**STATEMENT OF ENVIRONMENTAL EFFECTS: SECTION 75W APPLICATION TO MAJOR
PROJECT MP NO.09_0066, THOMAS STREET CAR PARK – AMENDMENT TO CONDITIONS**

Pursuant to Section 75W(1)(a) of the Environmental Planning and Assessment Act 1979, a 'modification of approval' is sought to vary the basement plans in Condition A2 pertaining to Major Project Approval MP No. 09_0066. The modification seeks to update the basement car parking plans with amended plans, that clearly identify the degree of encroachment of the basement car park underneath Fleet Lane.

A-0111 /B  
PRELIMINARY

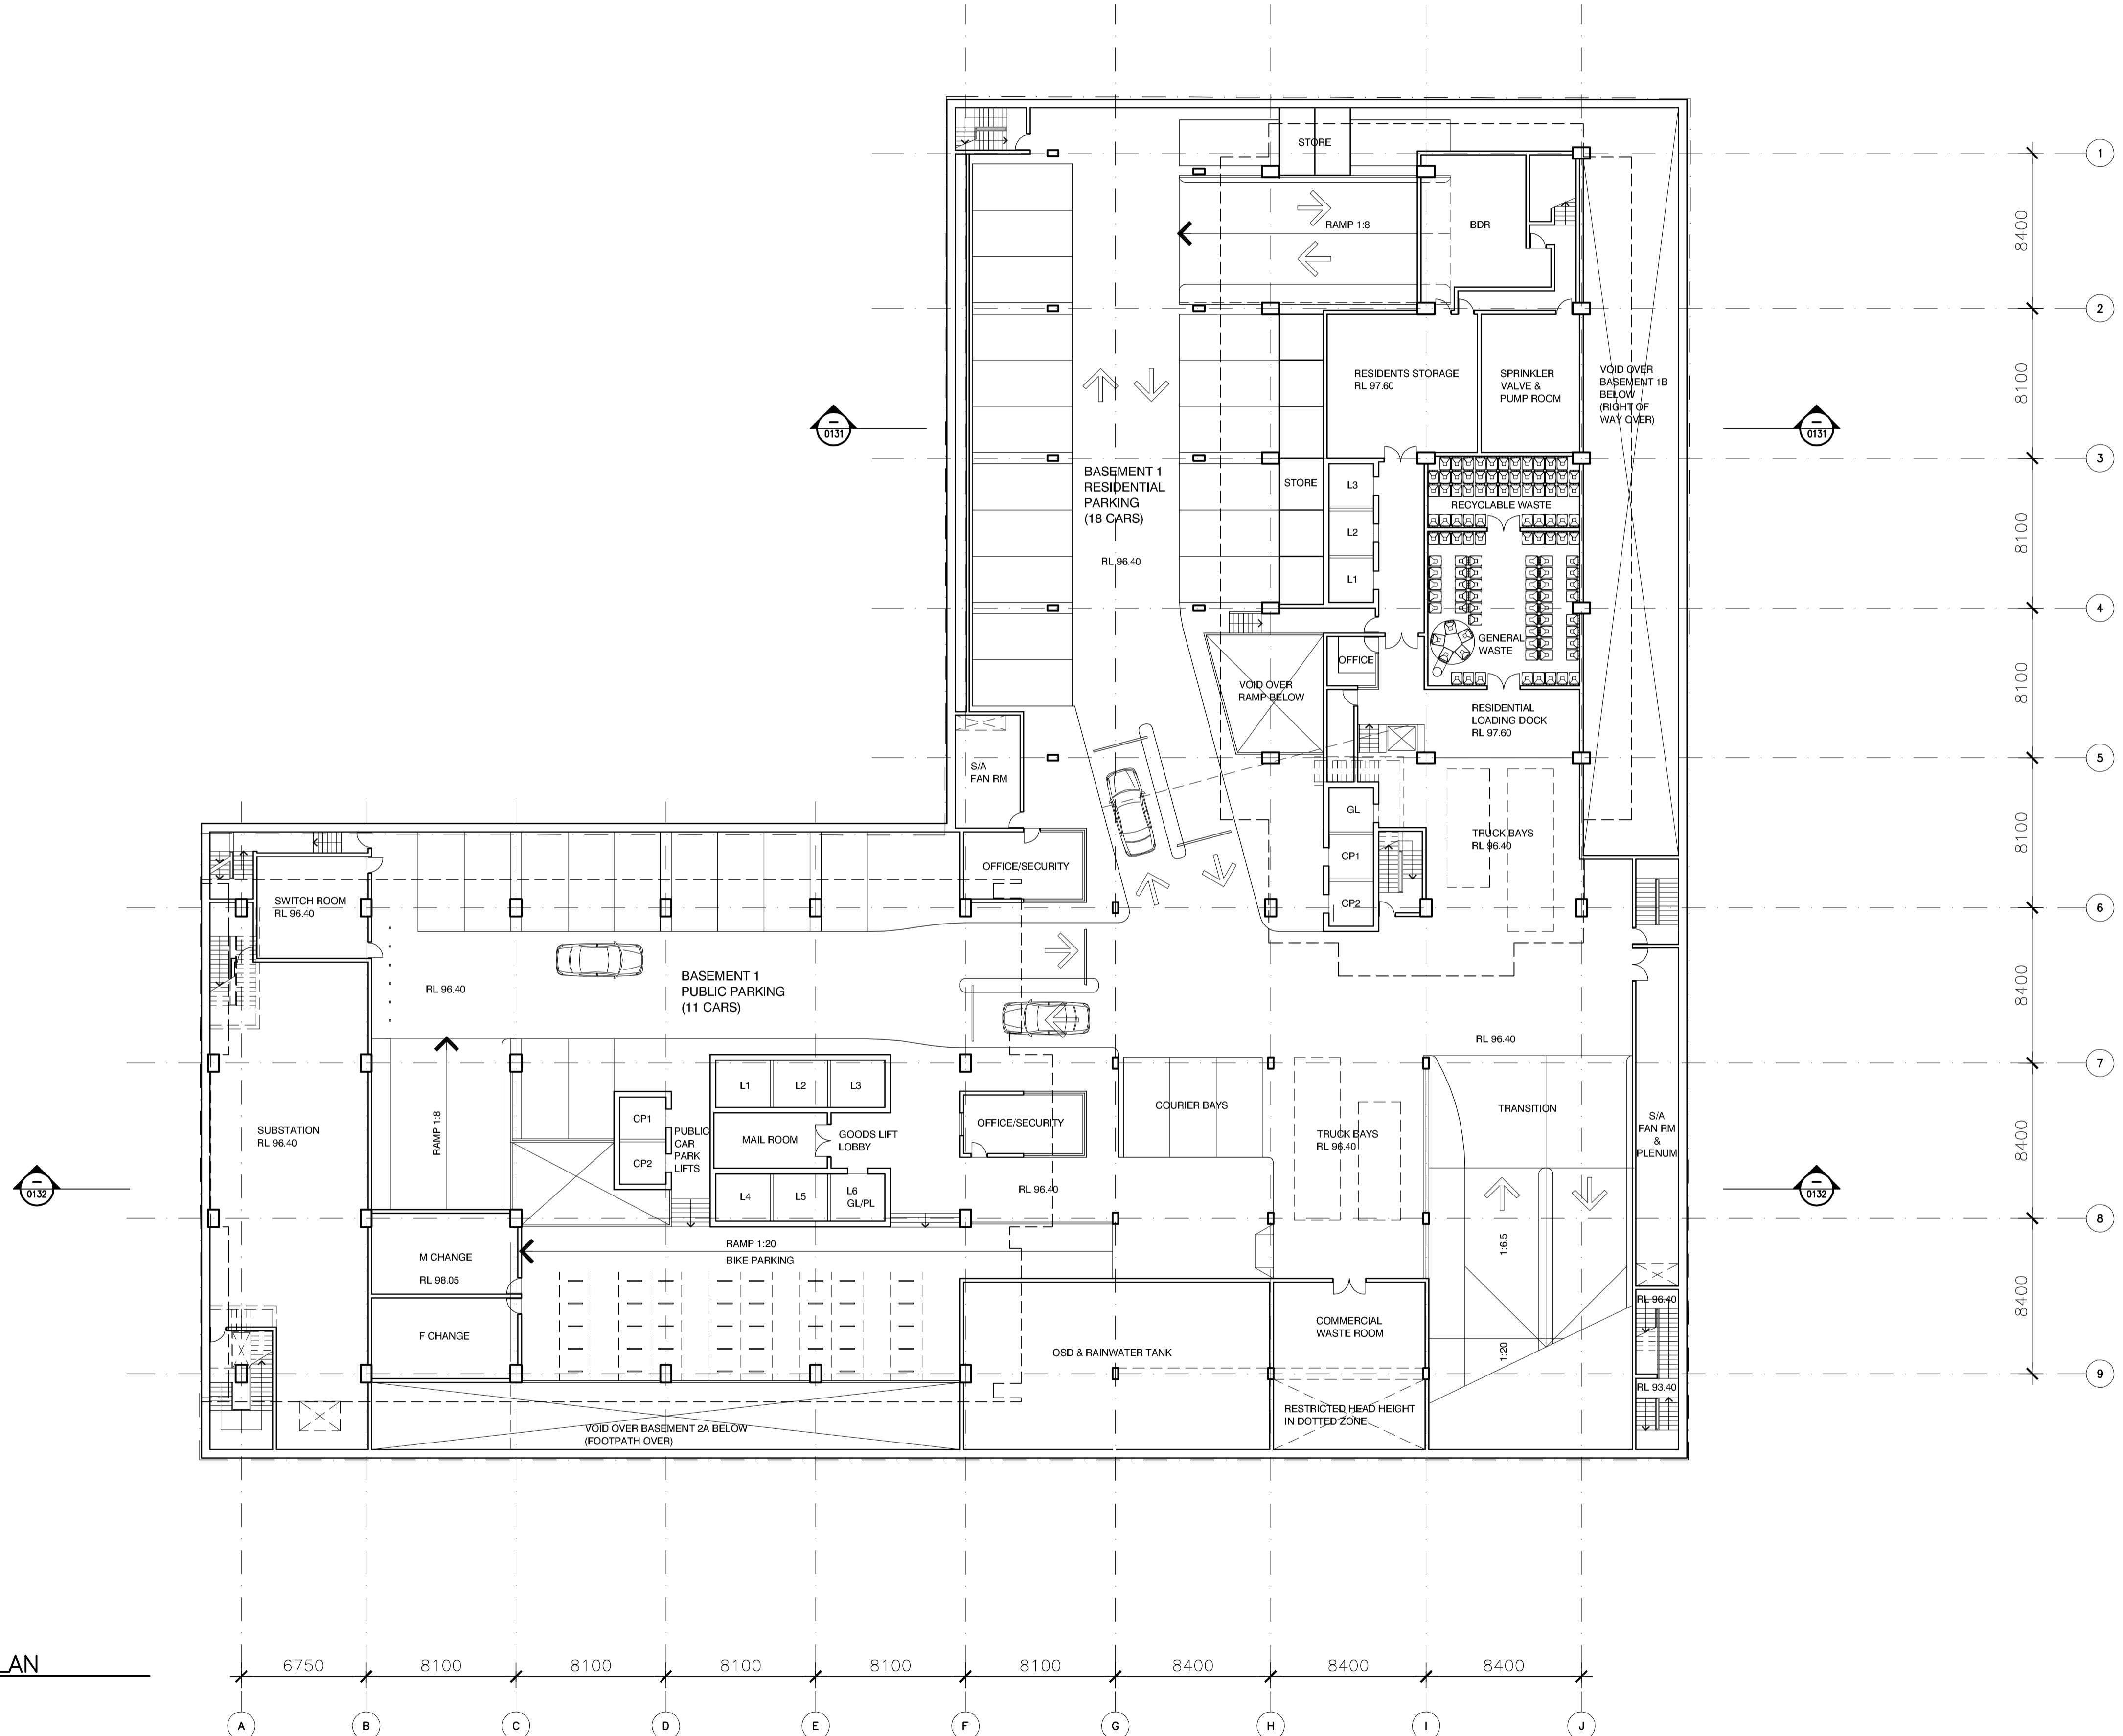
The reason for the modification to the basement plans is to clearly identify the extent of the encroachment under part of Fleet Lane. The need for the encroachment is expedient for the following reasons:

- The physical encroachment includes a portion of the car parks, the construction of the shoring wall and support pillars, which push beyond the boundary of the site; and
- The overall extent of the below ground level encroachment varies from 1,791mm to 1,882mm. On average it may be rounded up to a 2m encroachment.

Architectural Drawings prepared for the Environment Assessment/Preferred Project Report by PTW Architects			
Drawing No.	Revision	Name of Plan	Date
A-0111	F	Basement 1 plan	09/10/12
A-0112	F	Basement 2 plan	09/10/12
A-0113	F	Basement 3 plan	09/10/12
A-0114	F	Basement 4 plan	09/10/12
A-0115	F	Basement 5 plan	09/10/12
